Your Ref: OWPC18591
Our Ref: A/8/18/PL 26-01-2018
Please ask for:
Mrs A Gardner

Variation of condition 2 imposed under A/173/16/PL to read 'the development to be carried out in accordance with the following approved plans ADC 962/04 REVA, ADC962/13 & ADC962/14 relating to slight repositioning & change in size of building, revised position of rooflights on east, north & south elevations. This application affects the character & appearance of the Angmering Conservation Area.

Land Rear of 1 To 6 The Cottrells Angmering

A		Layout amended		10.11.17	
Rev		Description		Date	
Job Reference		Client			
New House The Cottrells Angmering, BN16 4AF		AM Homes Ltd			
Drawing Title		Drawing No		Rev	
Ground Floor Plan		ADC962/04		A	
Date	Scale	Dwg Size	Plot Style	Drawn	Checked
24.04.17	1:100	A3	ADC-red	TGS	AD

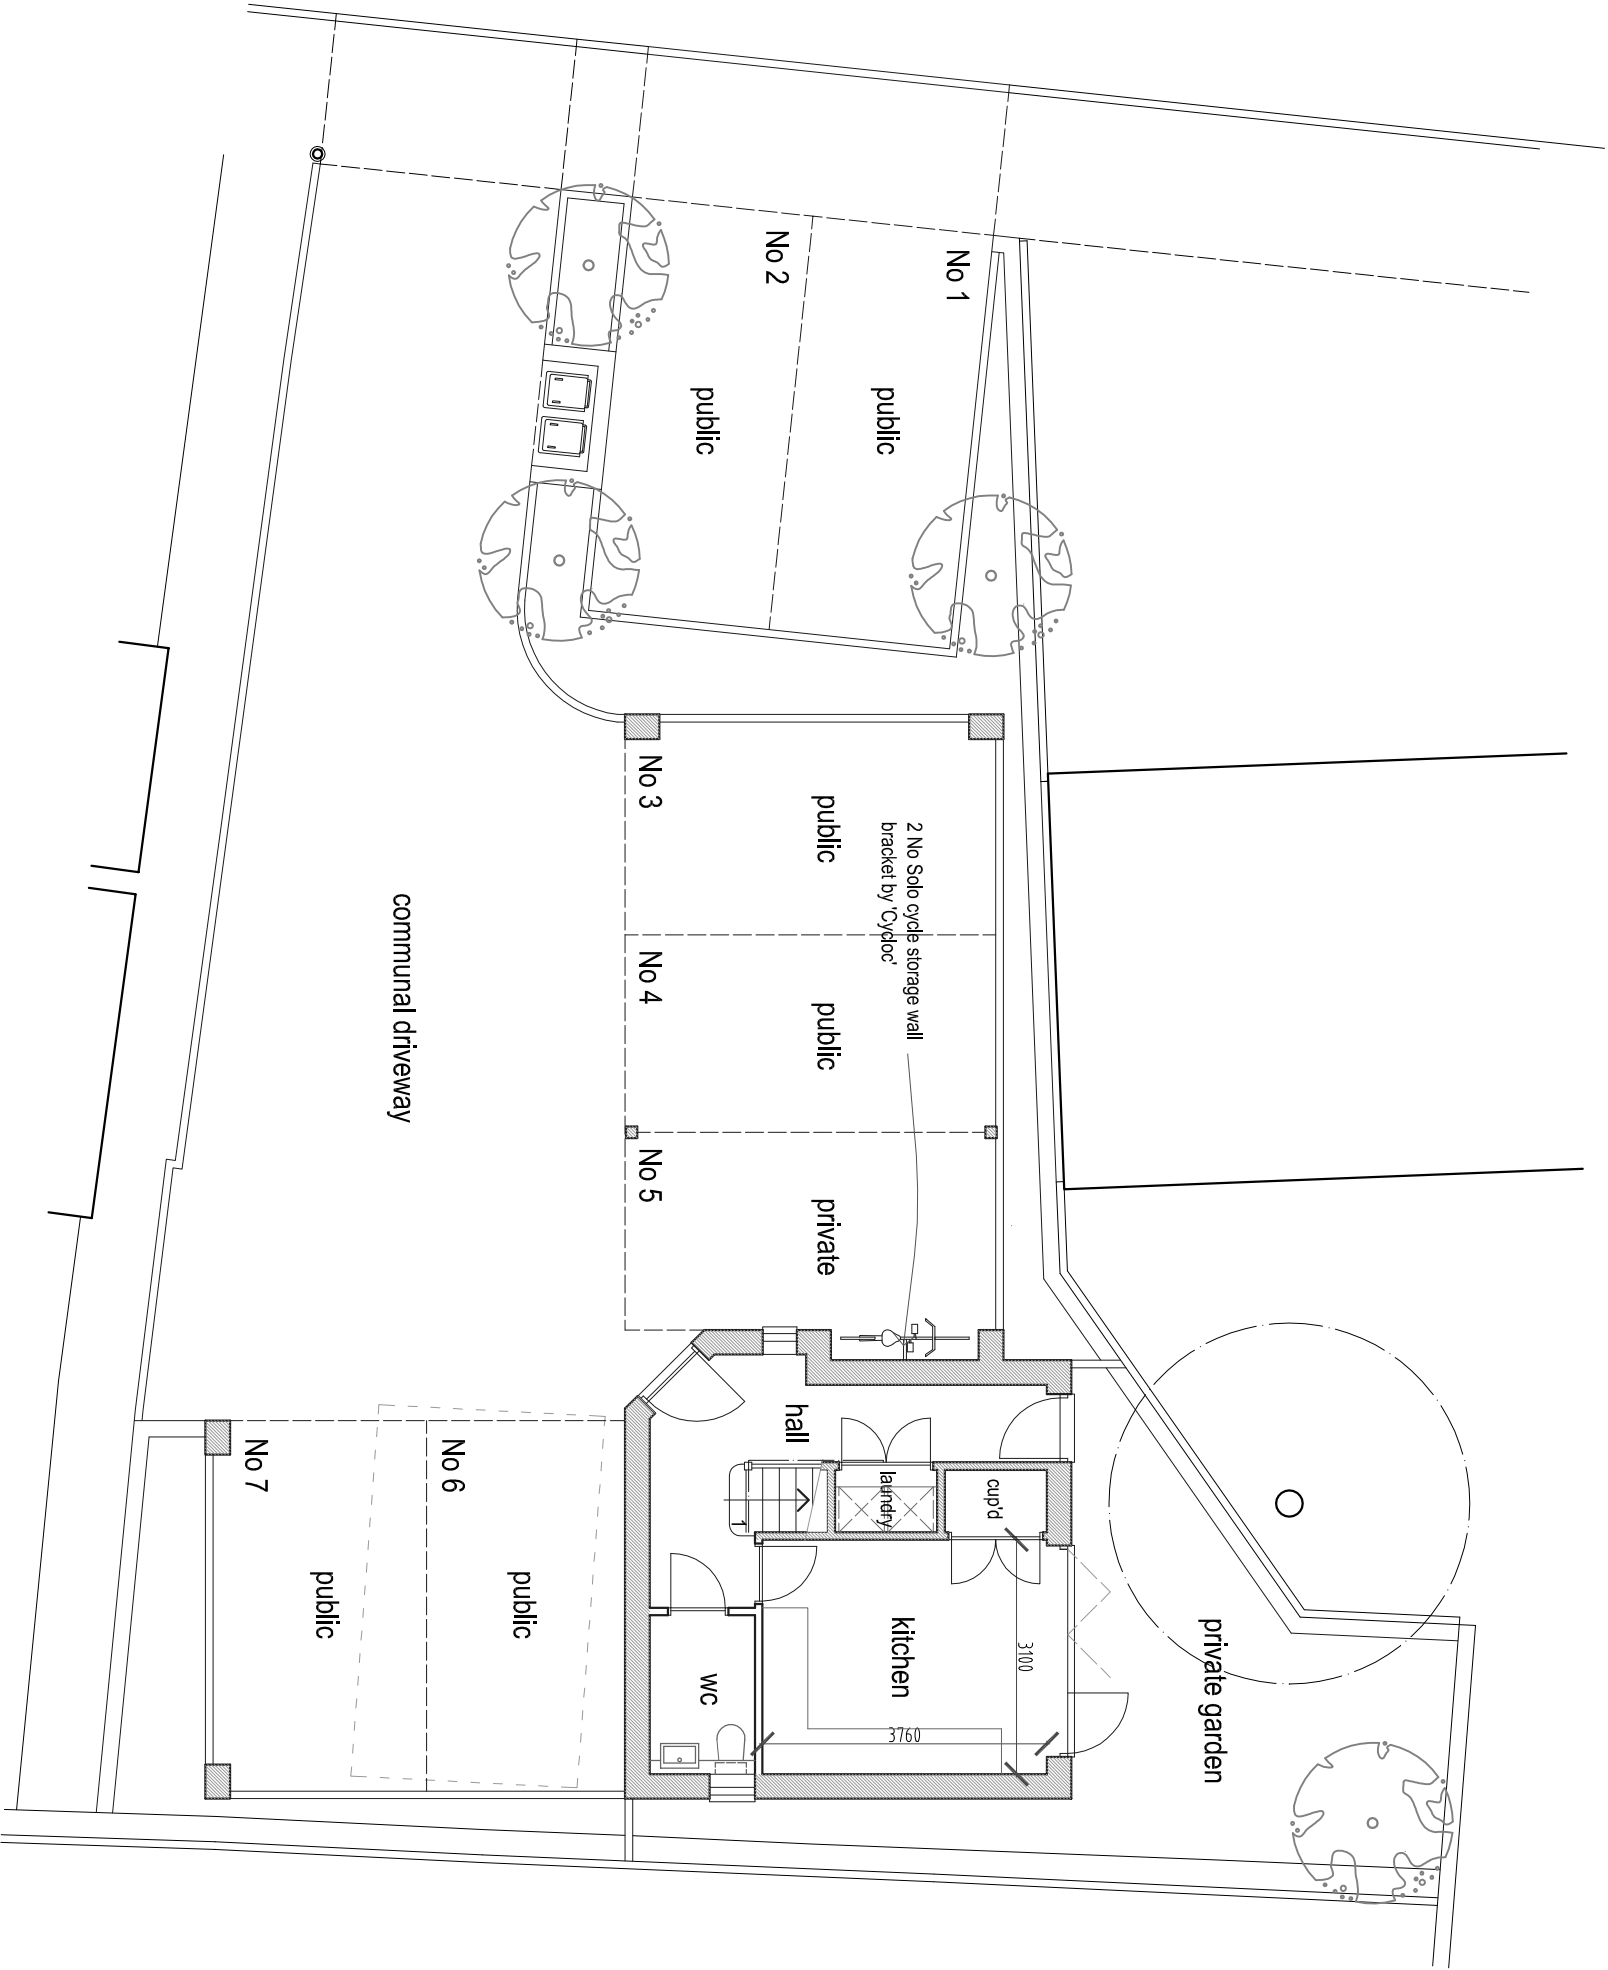
- 4. The development plans detailed two car parking spaces directly off from the road. These spaces would require a drop kerb for access. It appears that Mr Dodd has no intention of correcting this issue. This has not even been applied for via the Highways commission yet and without this the two spaces are rendered useless.*

Rev	Description	Date
Job Reference New House The Cottrells Angmering, BN16 4AF		
Client AM Homes Ltd		
Drawing Title First Floor Plan & Roof Plan		Drawing No ADC962/13
Date 16.01.18	Scale 1:100	Dwg Size A3
		Plot Style ADgrey.spl
		Drawn AD
		Checked AD

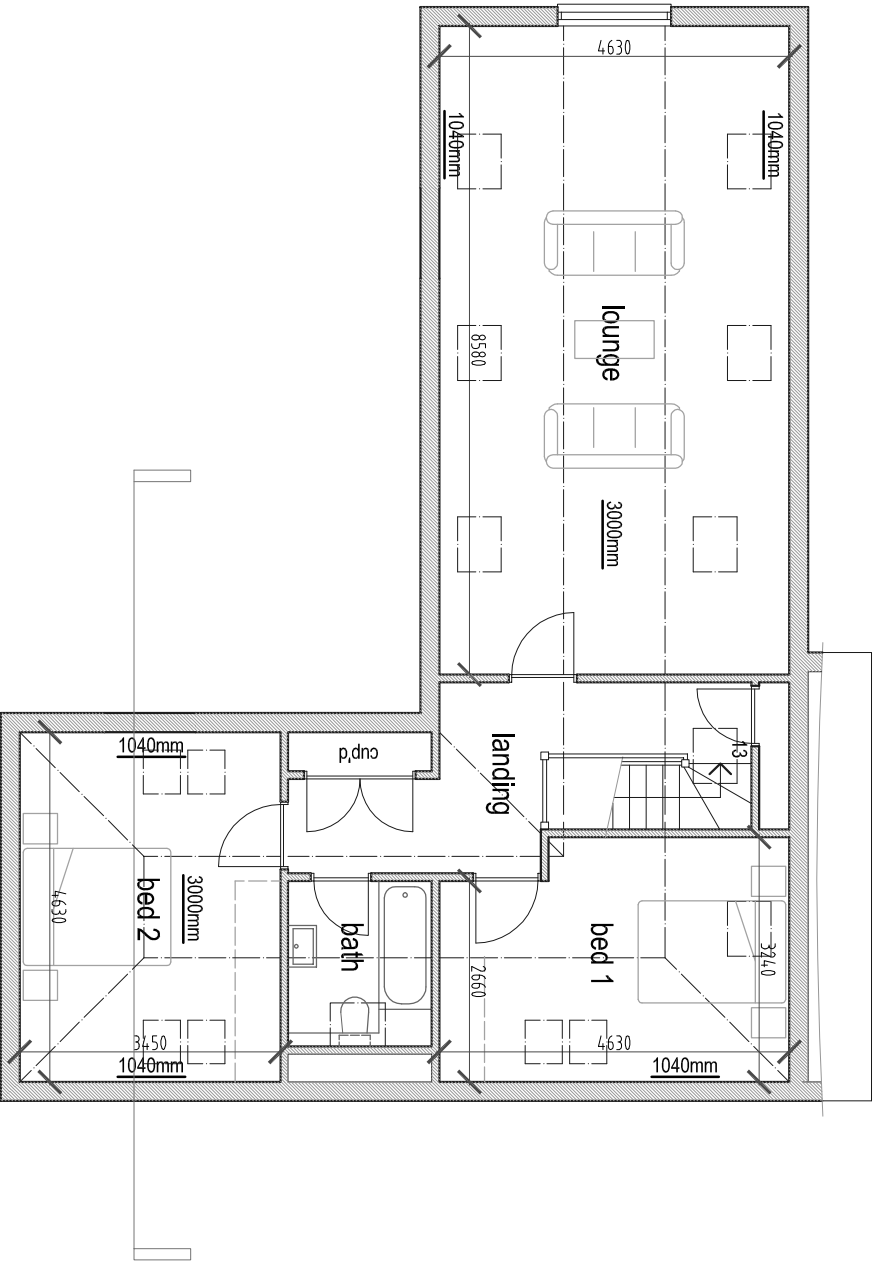
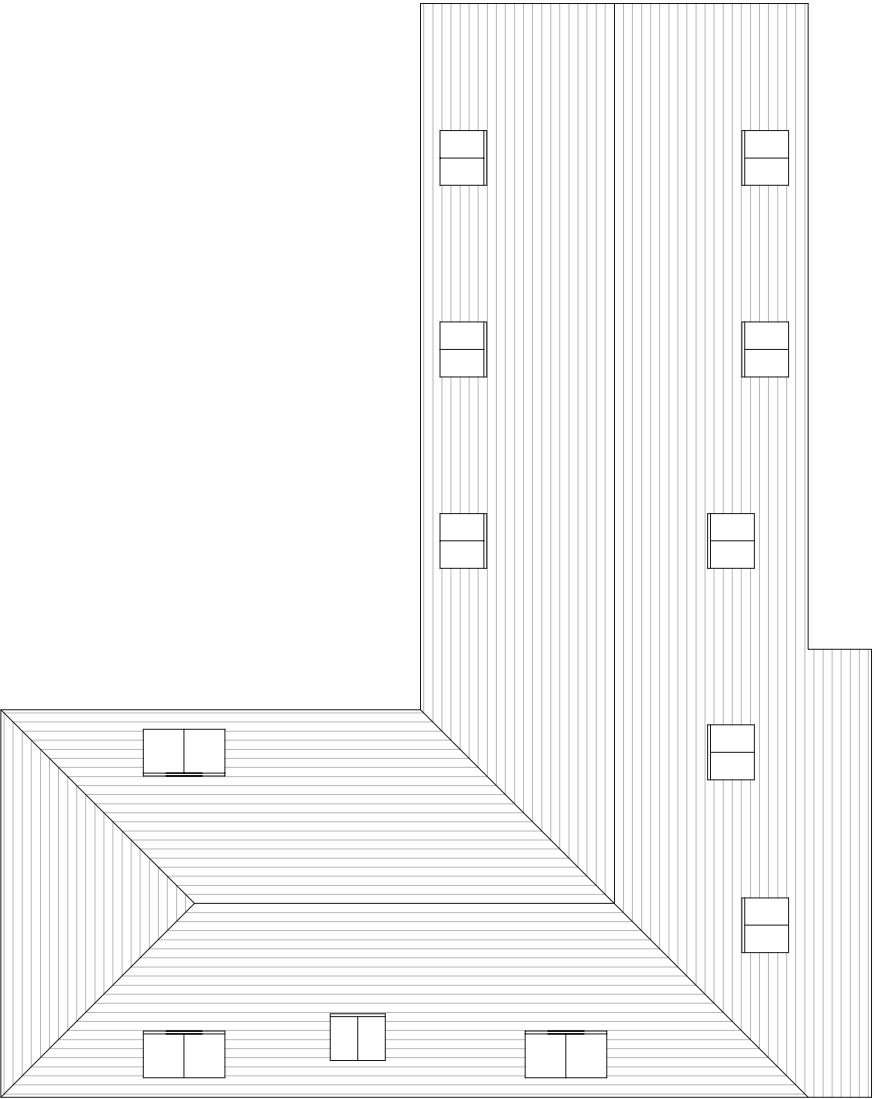
- 3. I believe that the internal layout of the property has been changed by putting a kitchen upstairs against planning approval so that a third bedroom can easily be accommodated in what has been called an occasional room. This is a blatant disregard for the planning process and an obvious attempt to increase the value of the development. This would most likely lead to the property requiring several car parking spaces and in an already congested road which does not have the capacity for its current occupants this would cause a great deal of further disruption.*

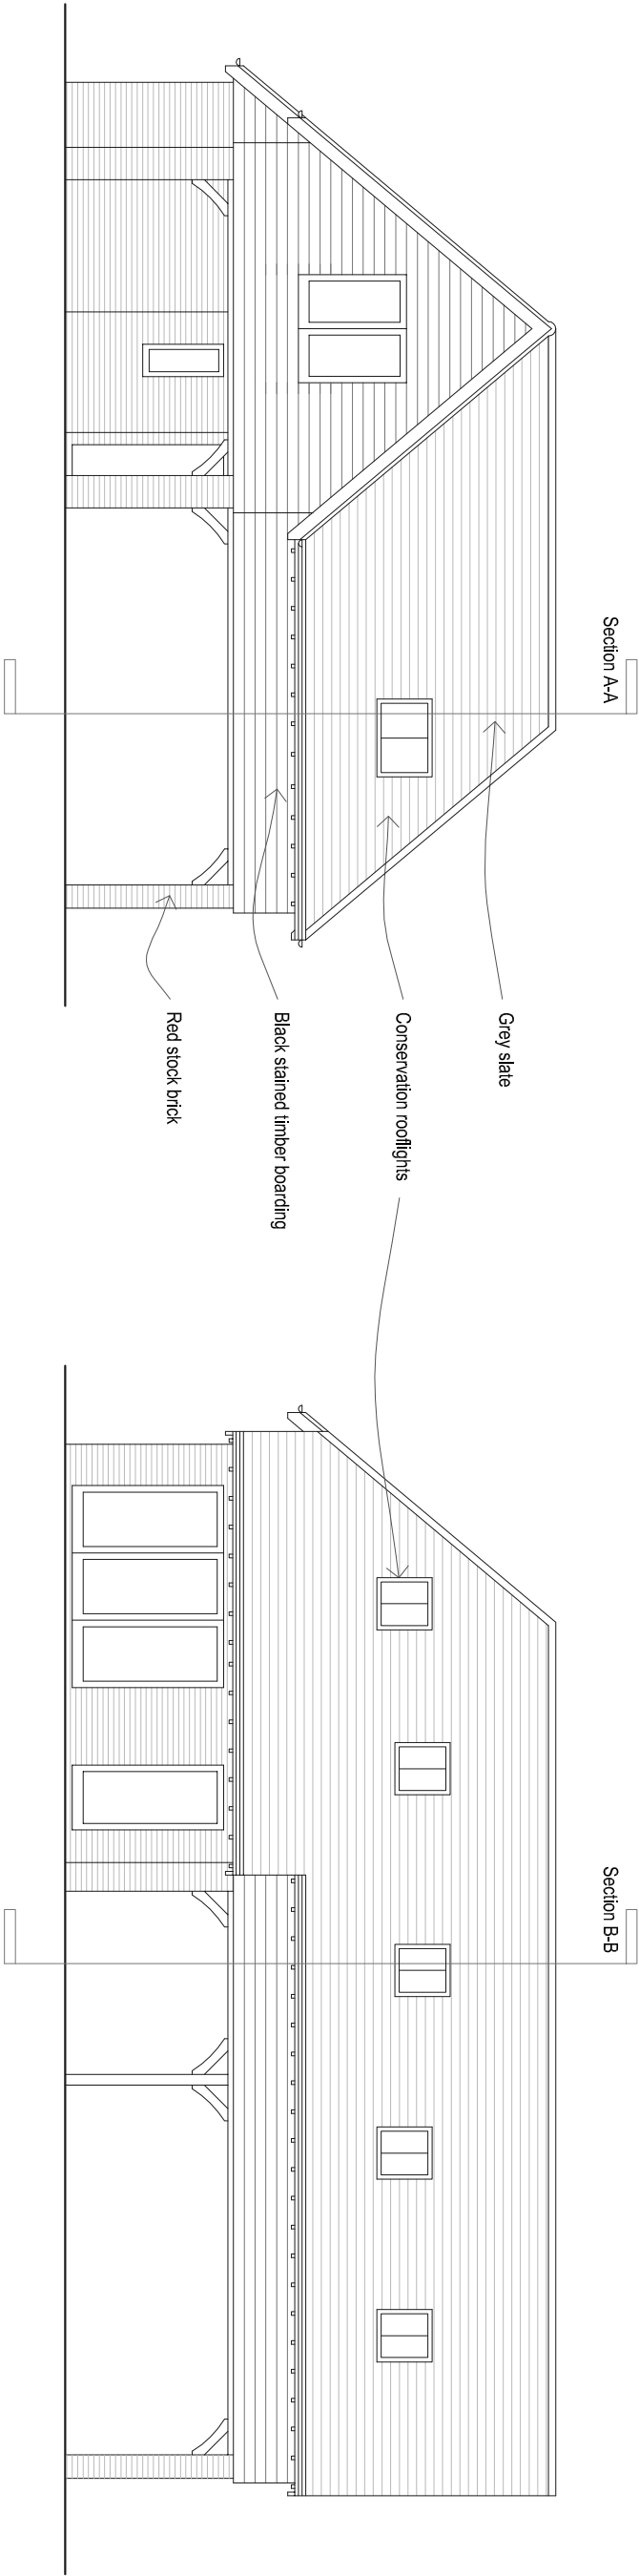
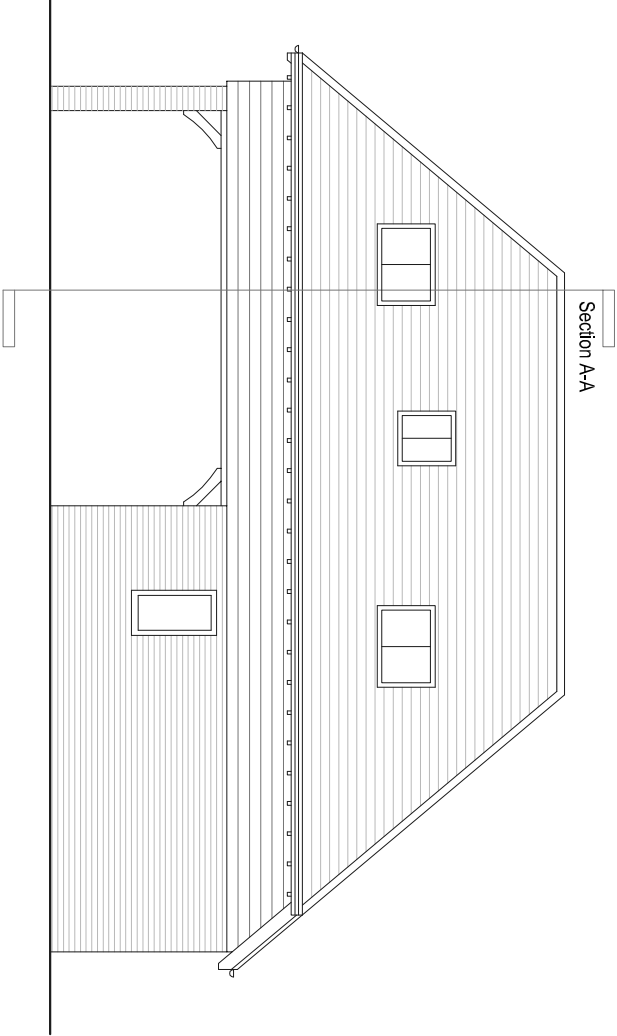
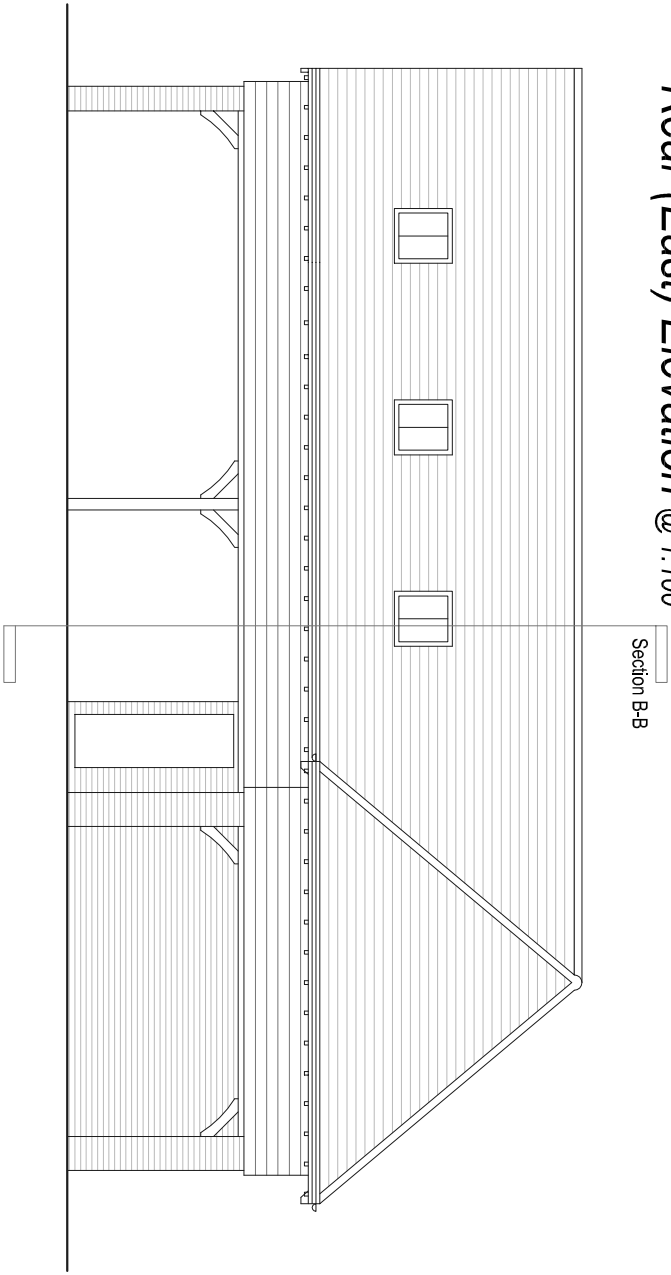
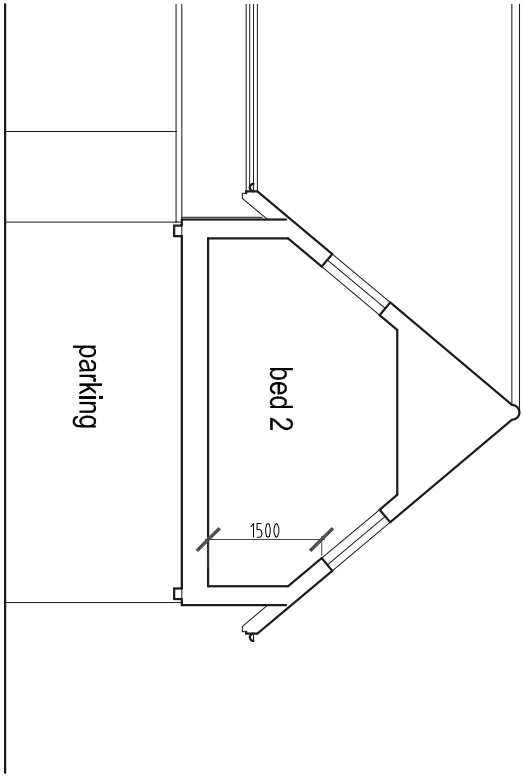
- 1. The term "rooflights" is misleading and incorrect. These are not rooflights but full size opening windows. When this build was approved it was on the condition that the privacy of the nearby residents was not encroached upon. These windows are in clear contradiction to this as they now look directly into my young daughter's bedroom. One window was supposed to be higher than the other two on this elevation but it is not. My 8 year old daughter now no longer wants to change in her bedroom as she has seen people looking out of the windows at her. This is not only an invasion of privacy but a possible case of child endangerment. Our garden is now also completely overlooked.*
